**RE: MAJOR PROJECT SSD 10421
WEIGALL SPORTS COMPLEX, SYDNEY GRAMMAR SCHOOL**

This submission is written on behalf of the owners of Strata Plan 11962 at 8 Vialoux Avenue, Paddington (the **neighbouring owners**) and is in respect of the above Major Project SSD 10421 (the **Major Project**) proposing a new Weigall sports complex (the **site**) for Sydney Grammar School comprising demolition of structures, construction of three-storey and single-storey building, ancillary works involving landscaping, tree removal, kiosk substation, car parking and signage.

Top: Sports Facilities Building - East Elevation  
Bottom: View along Vialoux Avenue

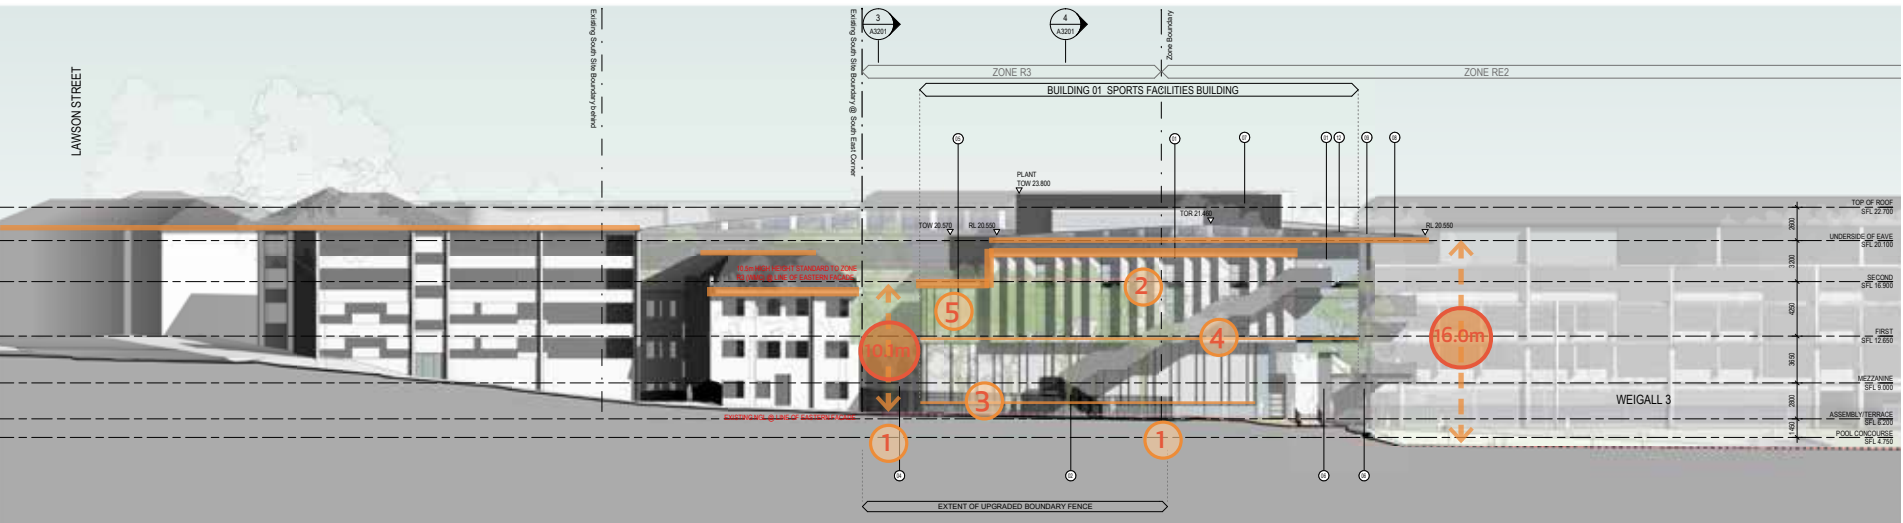
Additionally, and as demonstrated by **Figures 1 and 2** overleaf, the maximum building height for Building 1 provides for an inconsistent relationship with the neighbouring owners, directly to its south and precludes any northern outlook from the neighbouring owners.

Figure 1 – Proposed Building 1 eastern elevation with the smaller built form of 8 Vialoux Avenue immediately adjacent (source AJ+C Architectural Drawings)
